SKP V_2.pdf Markup Summary

NEIGHBORHOOD COMMERCIAL 15.4 AC
SHEET INDEX
SHEET 1 OF 3: COVER SHEET
SHEET 2 OF 3: SKETCH PLAN
SHEET 3 OF 3: ADJACENT PROPERTY OWNERS MAP
SHEET 4 OF 4: PHYSICAL FEATURES MAP
GRANDVIEW RESERVE SKETCH PLAN
COVER SHEET

GRANDVIEW RESERVE SKETCH PLAN
 COVER SHEET

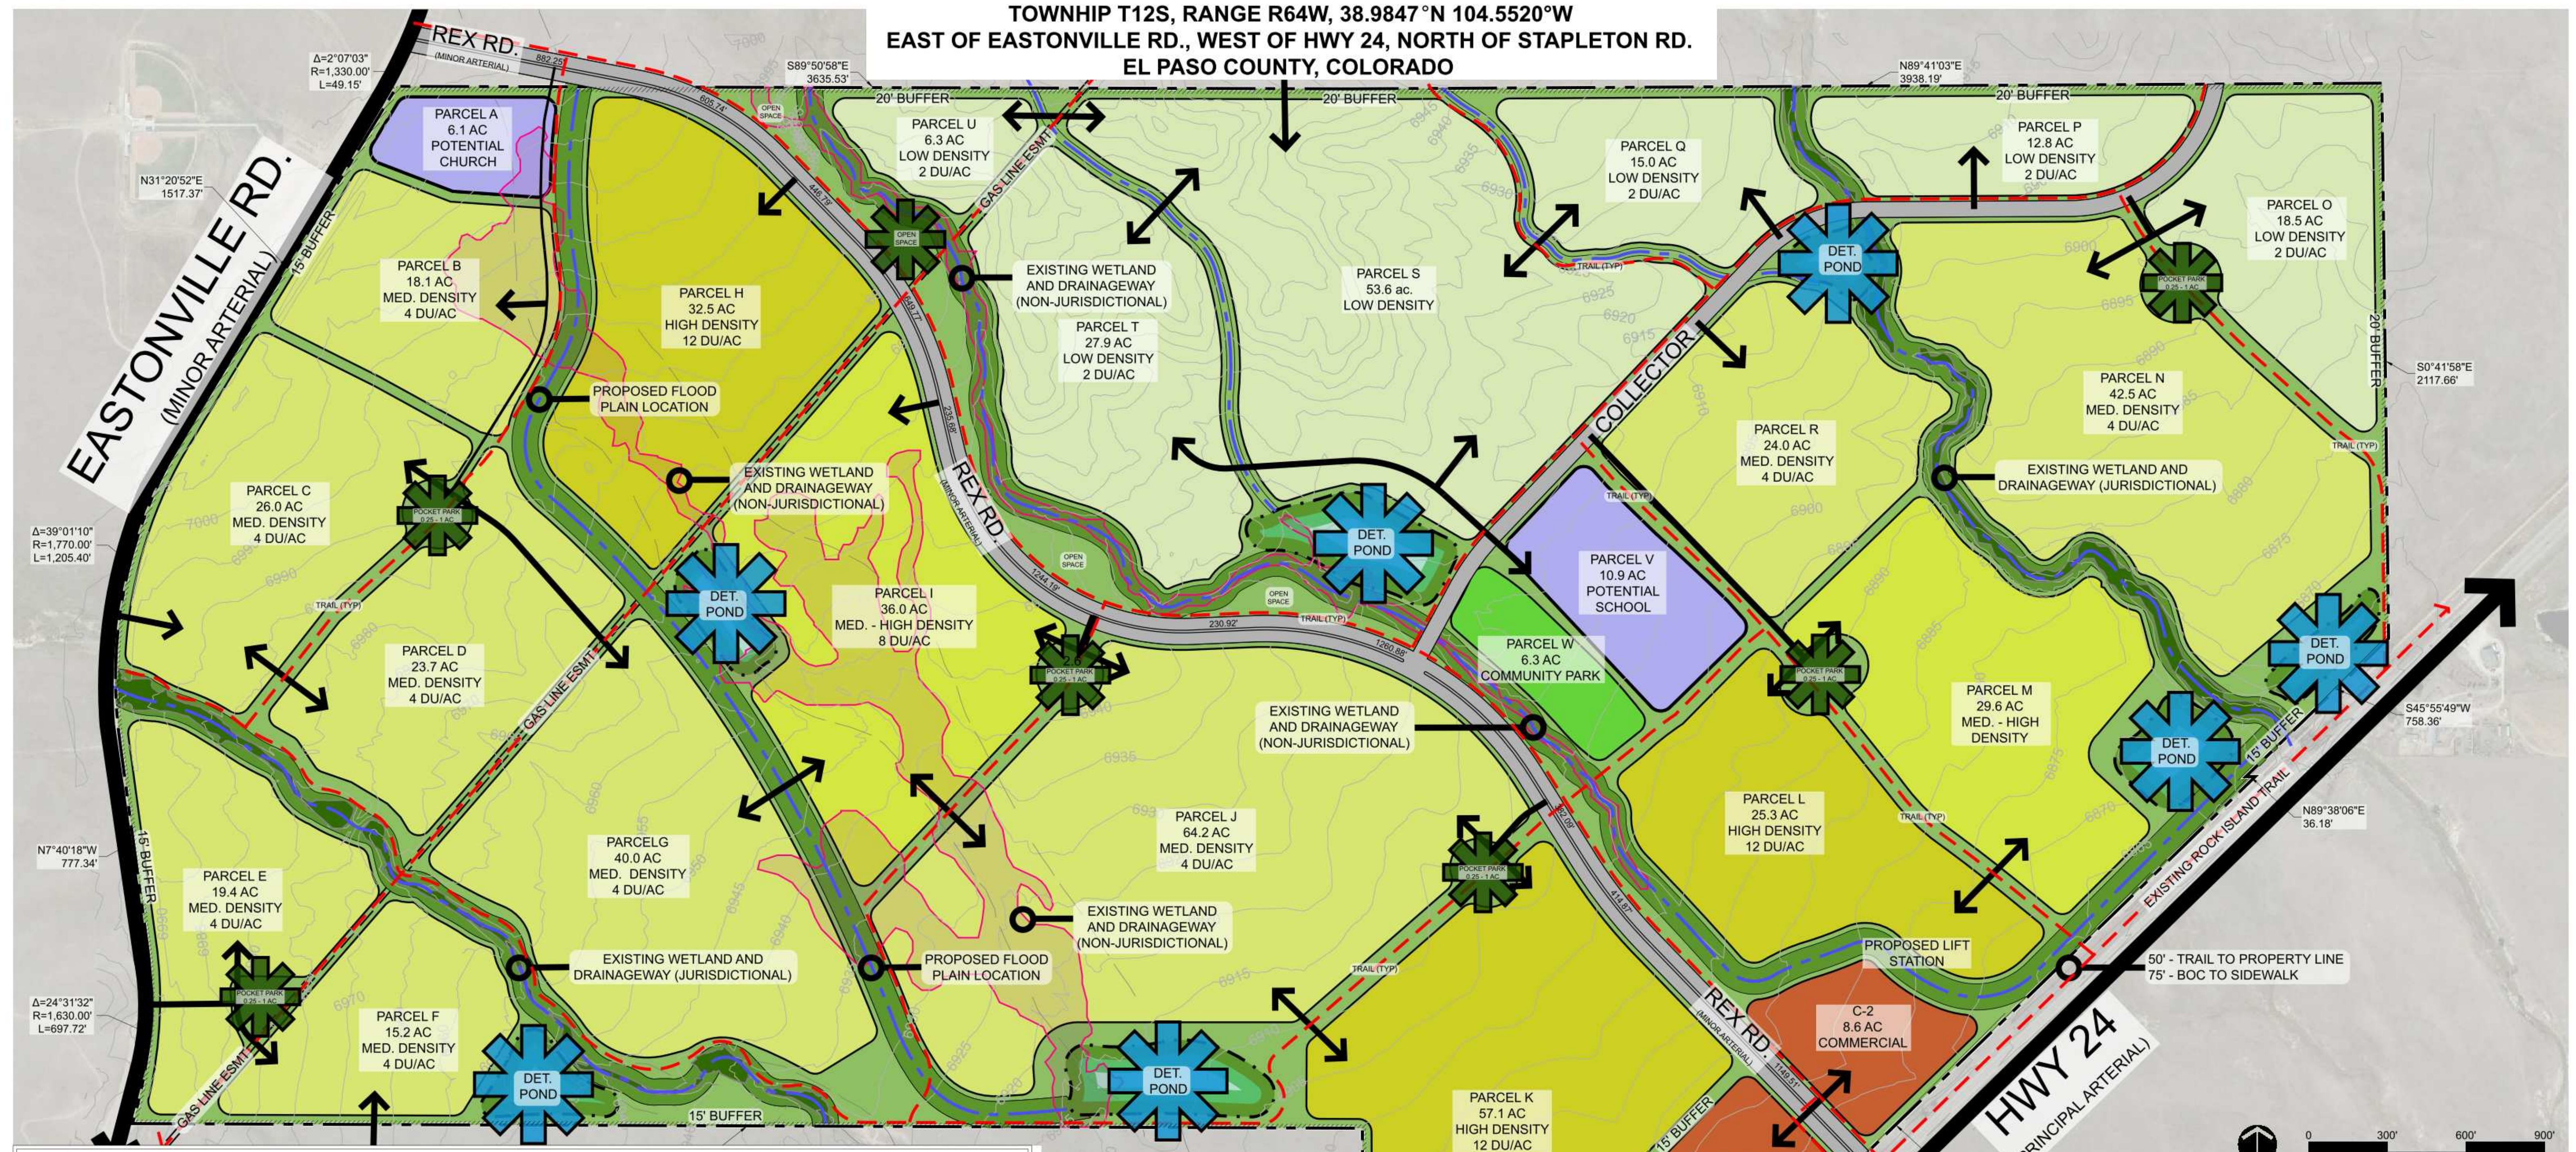
Subject: Text Box
Page Index: 1
Date: 8/5/2020 7:21:11 PM
Author: dsdrice
Color: 
Layer:
Space:
Page Label: 1

SHEET 4 OF 4: PHYSICAL FEATURES MAP

Subject: Cloud+
Page Index: 1
Date: 8/5/2020 7:21:45 PM
Author: dsdrice
Color: 
Layer:
Space:
Page Label: 1
